WA/60/15/HH - 6 NASH WAY, WALBERTON, WEST SUSSEX

We are writing in connection with the proposed extension of the above property.

**A102**

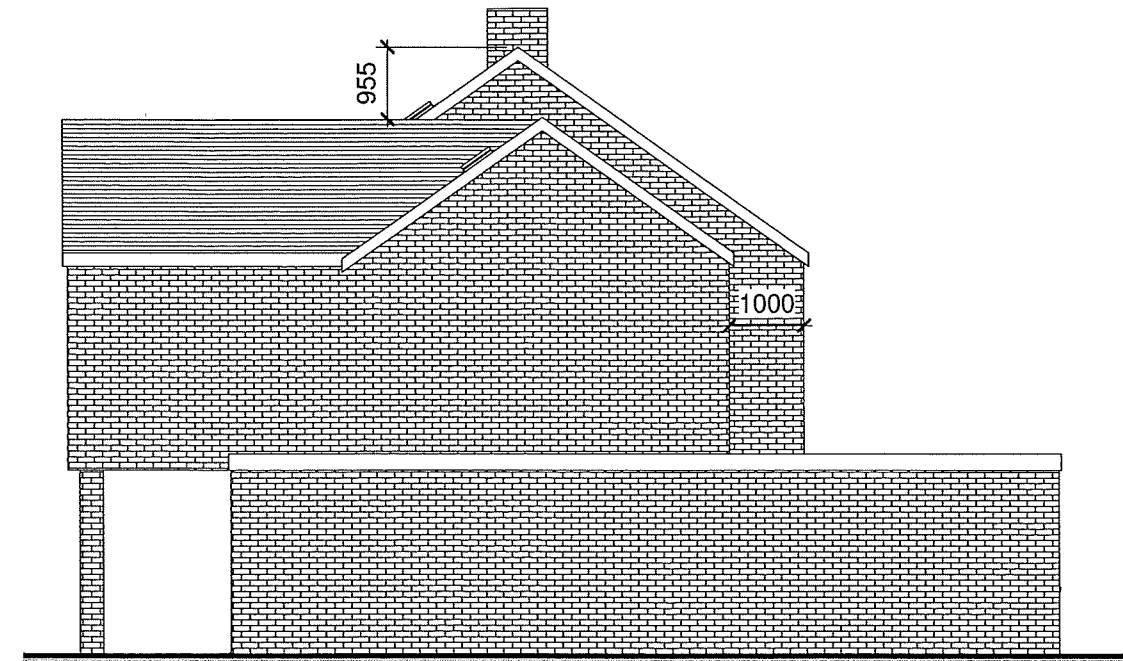
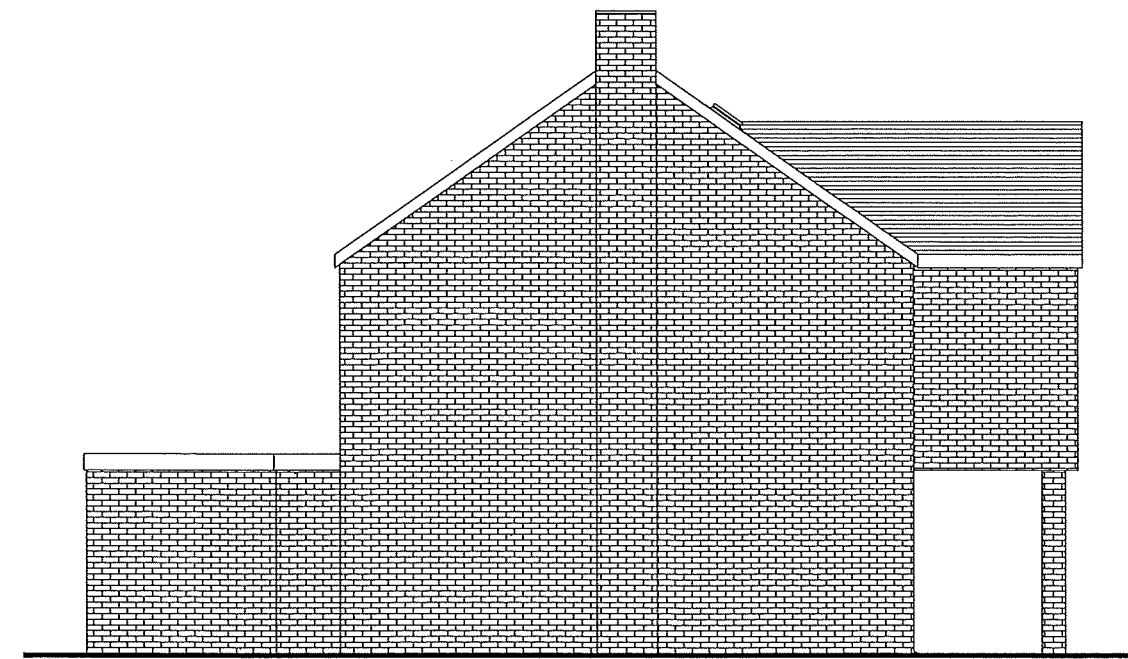
We wish to officially object to any structure to be built in the shaded area shown on the attached sketch. The reason for this objection is that it would entirely cut out the morning sunlight from the utility/kitchen and dining room casting that half of the house into permanent shade.

A104

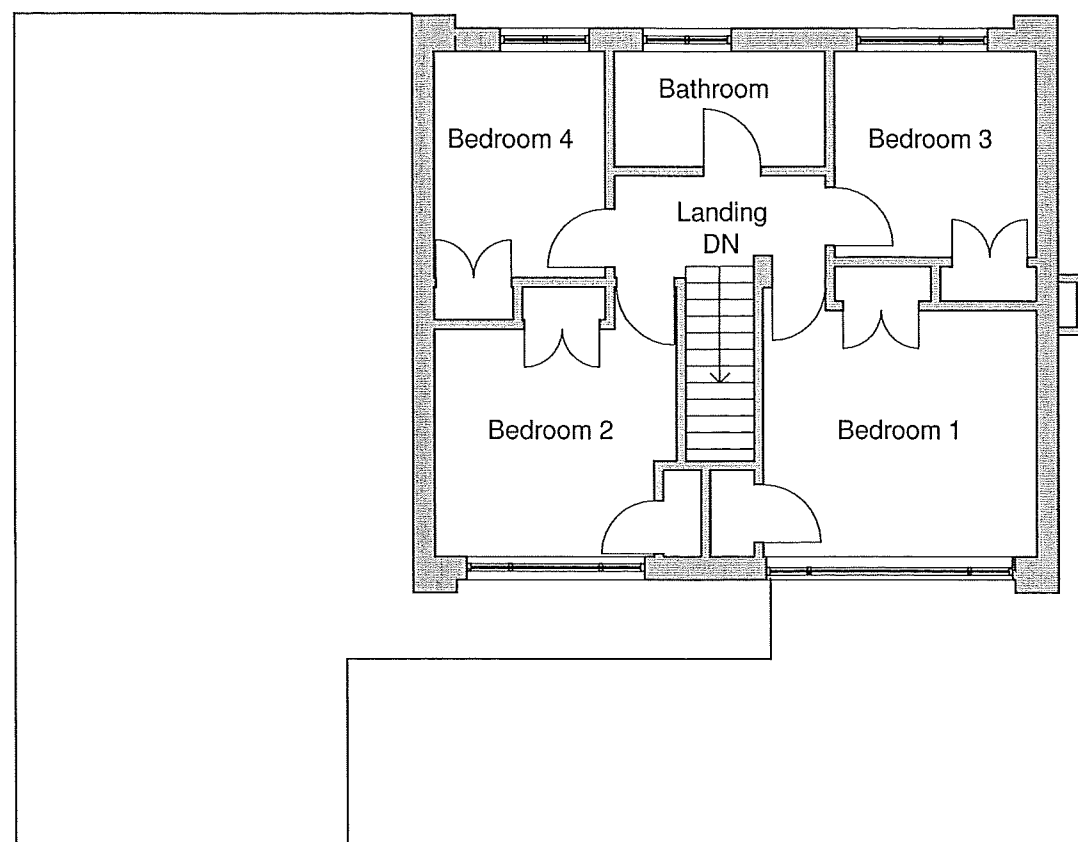
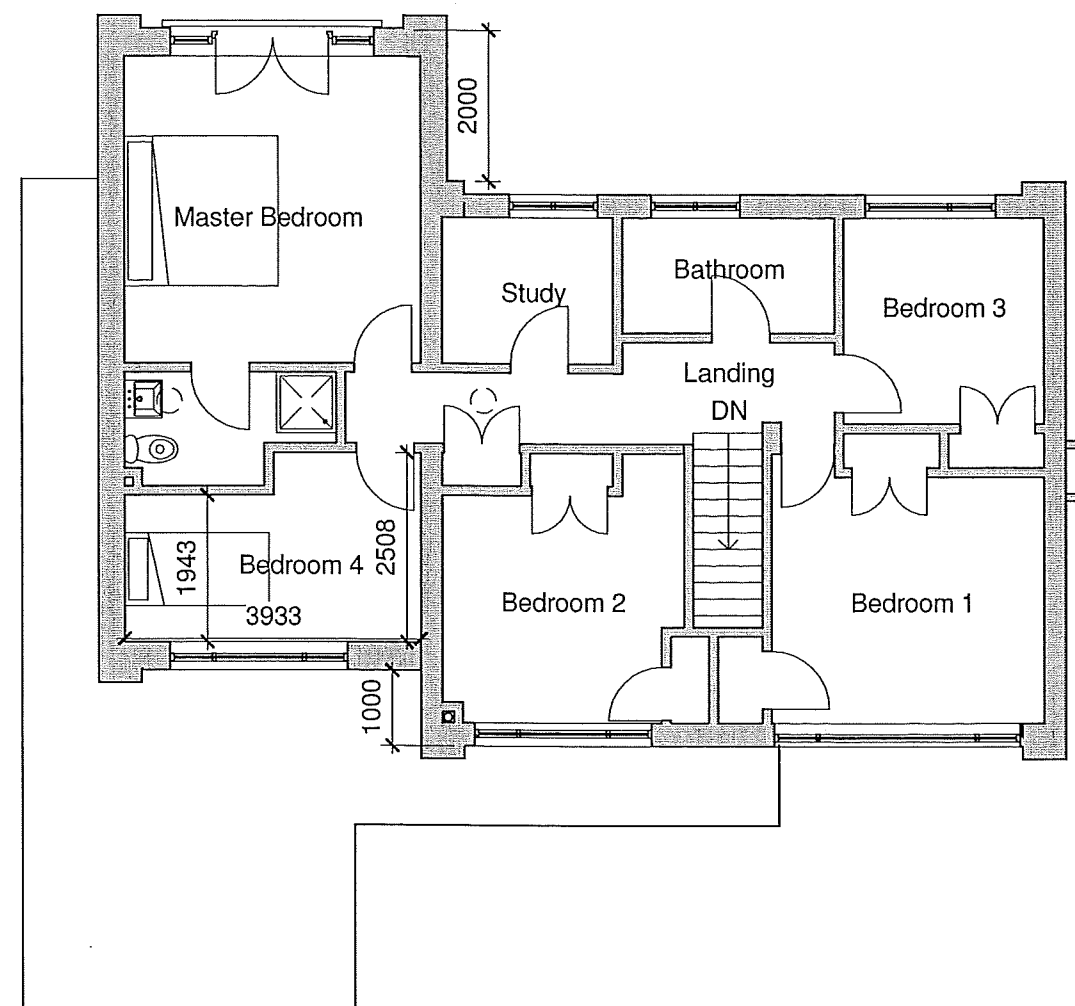
Since the existing extension of Number 6 has been built right up to the boundary, a first floor extension above it so close to the edge would inhibit an open aspect and create an enclosed and claustrophobic atmosphere - this would also be very un-neighbourly.

For that and the above reasons, we would ask for a 3m gap between the edge of the new construction to the boundary of our property.
